## Stage 1 Road Safety Audit Response Report

Project No: ITM10127  
Project Title: Capitol Park, Leeds  
Title: Stage 1 Road Safety Audit – Response Report (Proposed M62 Junction 28 Improvements: Phase 1)  
Ref: ITM10127-016B TN  
Date: 17 October 2022

***The safety audit relates to highway works at the M62 J28 proposed by Capitol Sterling and CC Projects as part of two separate planning applications, detailed in the Stage 1 RSA Brief. The works have been agreed in principle with Leeds City Council and National Highways. The proposed works have been split into two phases, with this response report dealing with the Phase 1 works. Phase 1 includes works to the A563 Dewsbury Road and associated downstream circulatory, road marking amendments on the M62 eastbound off-slip, widening of the northern circulatory to provide an additional lane and provision of two lanes at the M62 eastbound on-slip. This phase also includes upgrading existing footway/cycleway provision in the south western corner of the junction and new pedestrian and cycle provision around the western, northern and eastern sides of the junction with additional crossings provided at the A653 Dewsbury Road (northern arm) a

Drawing Title
**MITIGATION SCHEME
FEASIBILITY DESIGN
GENERAL ARRANGEMENT**

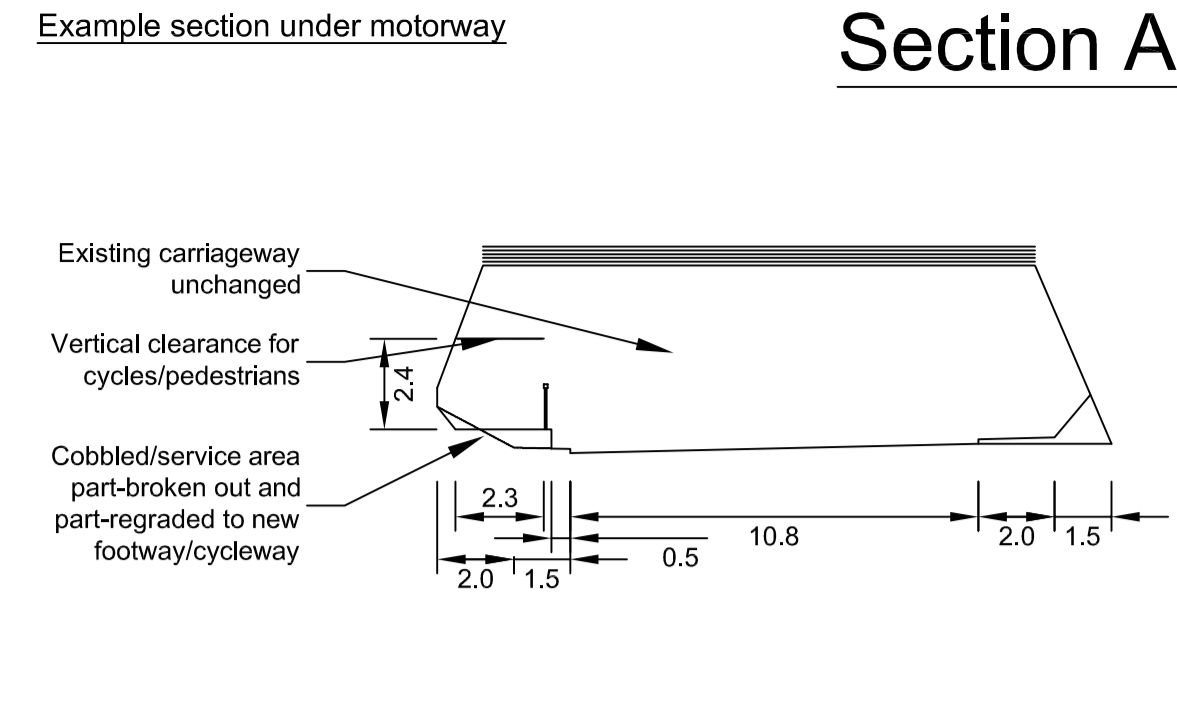
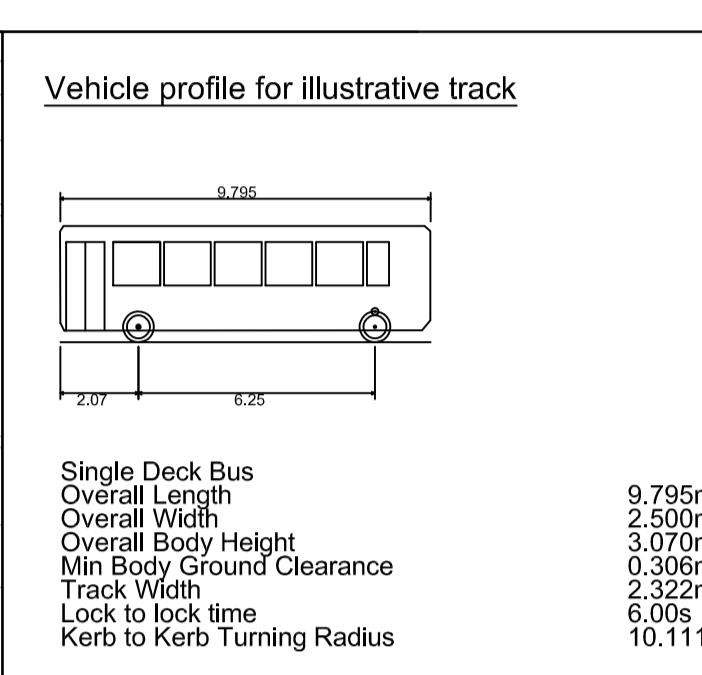
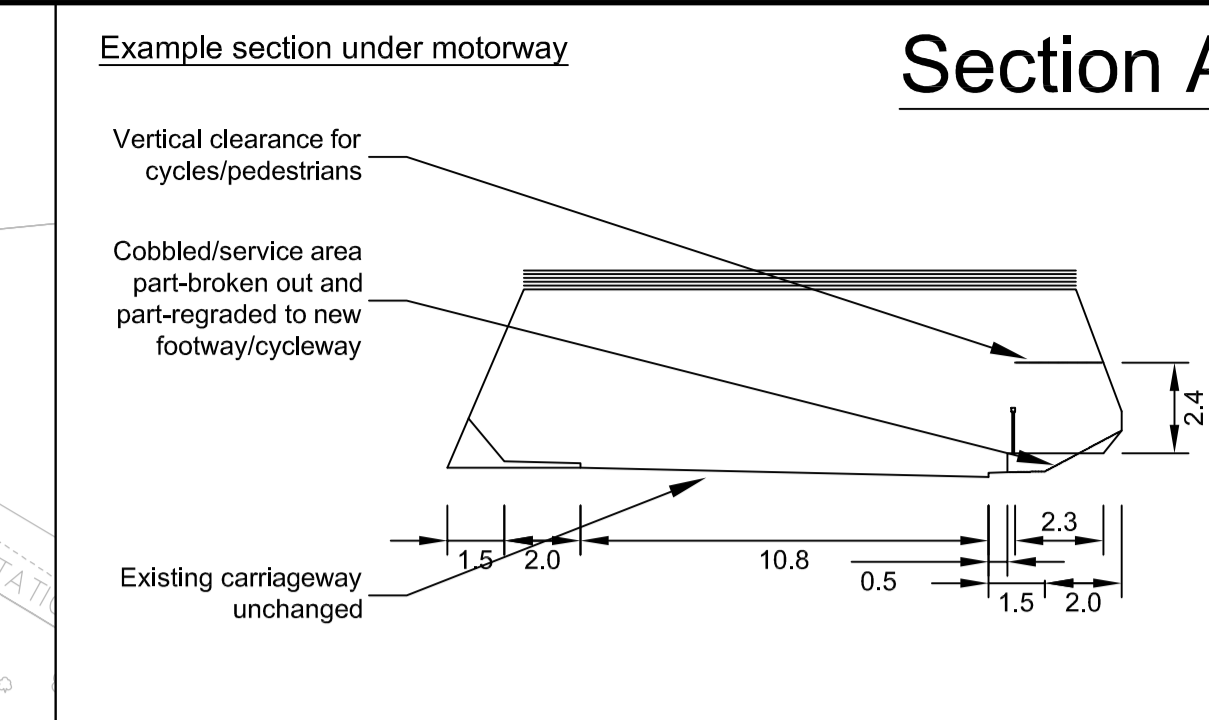
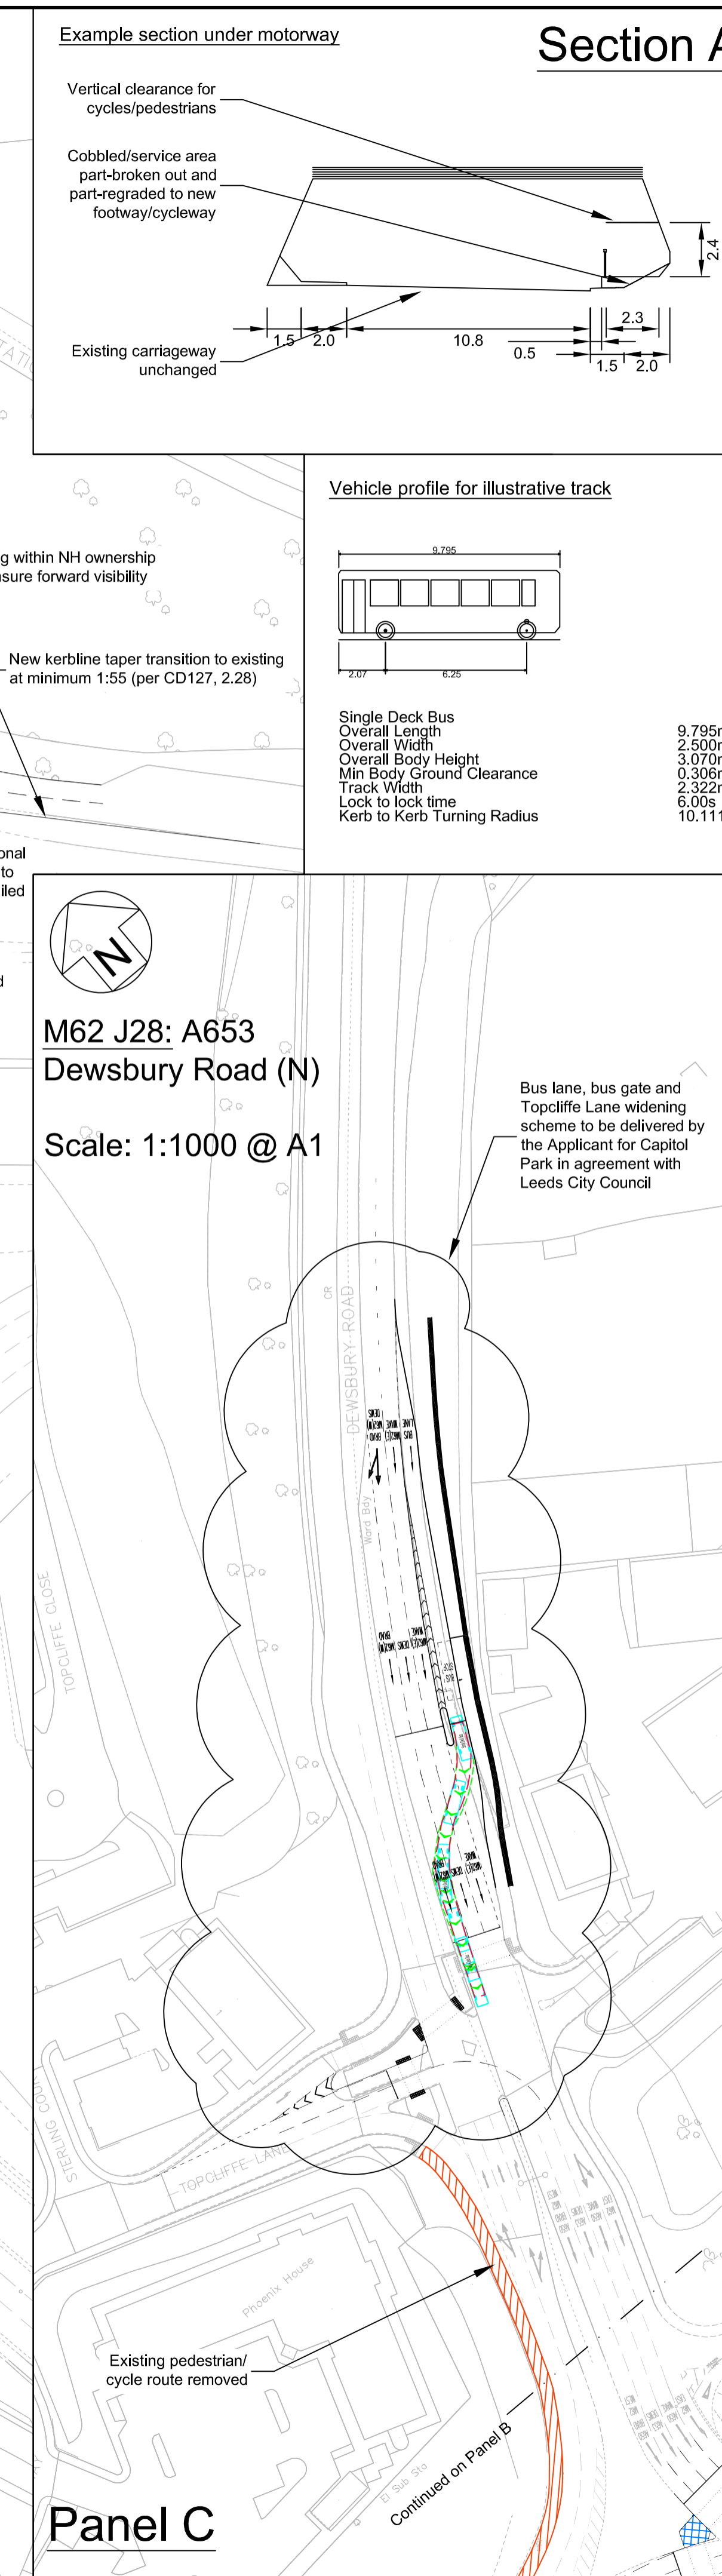
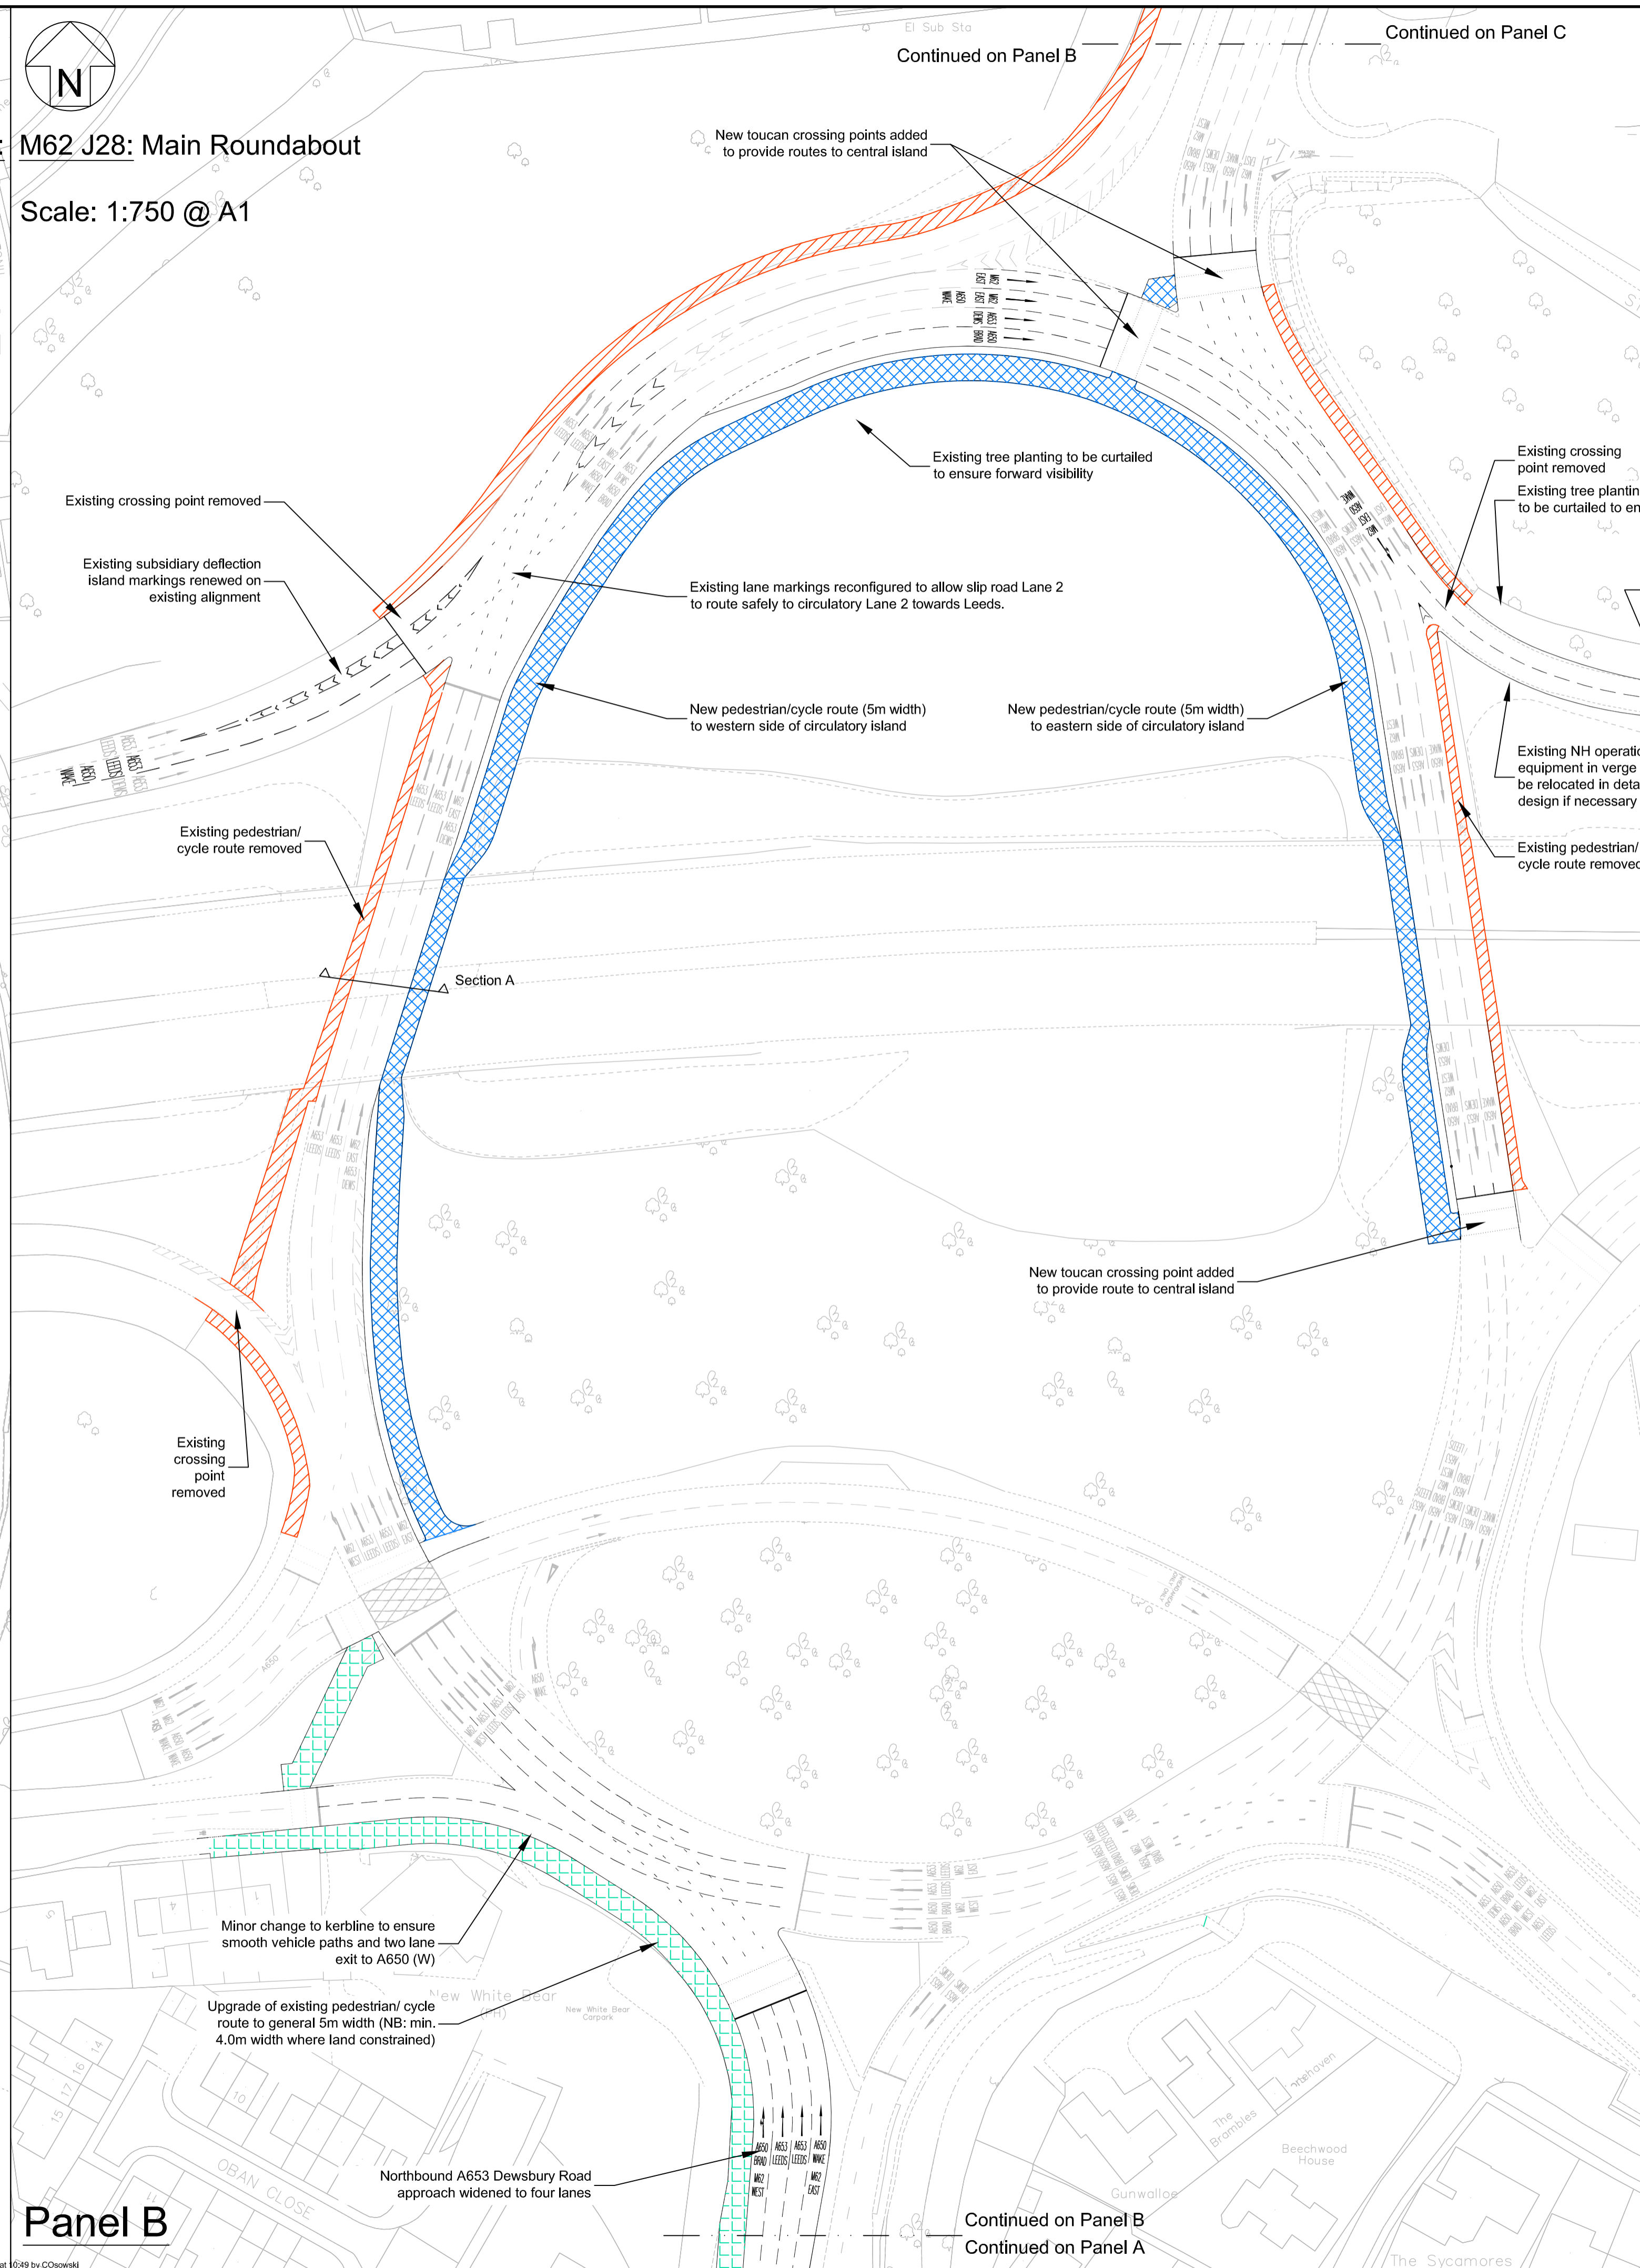
Ref:	RSA Problem	RSA Recommendation	Design Organisation Response	Overseeing Organisation Response	Agreed RSA Action
3.1	<p>Location: The Dewsbury Road northbound approach to the roundabout.</p> <p>Summary: The nearside lane marking could confuse motorists and increase the risk of collisions.</p> <p>The nearside lane worded destinations are correct (A650 and M62), but the arrow shows the lane as left-turn only. Motorists, particularly those unfamiliar with the area and intending to access the M62 west, could be led to believe that they should stay in the nearside lane, then brake and manoeuvre suddenly at the A650 exit to regain the correct lane on the circulatory on their offside. This could increase the risk of tail-end or side-swipe collisions with following motorists in that lane.</p>	<p>It is recommended that the left-turn arrow is replaced with a double-headed straight-ahead and left-turn marking.</p>	<p>The recommendation is accepted. The nearside lane marking has been amended in Revision H of the scheme drawings, enclosed at <b>Appendix A</b>.</p>	<p>The recommendation is accepted.</p>	<p>Nearside land marking amended</p>

Ref:	RSA Problem	RSA Recommendation	Design Organisation Response	Overseeing Organisation Response	Agreed RSA Action
3.4	<p>Location: The amended northern section of the circulatory carriageway.</p> <p>Summary: Reduced visibility of the offside traffic signals could increase the risk of collisions.</p> <p>A fourth lane is shown to be developed on the offside approach to the traffic signals and proposed Toucan crossing opposite Dewsbury Road. Notwithstanding that some site clearance will be required on the central island to provide the lane and the footway/cycleway, there is heavy foliage present which could compromise forward visibility to the offside signal head. In turn, this could increase the risk of last minute braking and tail end collisions.</p>	<p>It is recommended that the foliage is removed or cut back sufficiently to provide adequate forward visibility to the offside signal head, bearing in mind the potential for re-growth.</p>	<p>The recommendation is accepted. Foliage will be cut back as part of implementing the proposed works.</p> <p>However on-going maintenance of the foliage will remain the responsibility of the Local Highway Authority (as is presently the case).</p> <p>Annotation to the above is included in Revision H of the scheme drawings, enclosed at <b>Appendix A</b>.</p>	<p>The recommendation is accepted. Foliage will be cut back as part of implementing the proposed works and maintained thereafter by LCC.</p>	<p>Foliage will be cut back as part of implementing the proposed works and maintained thereafter by LCC</p>
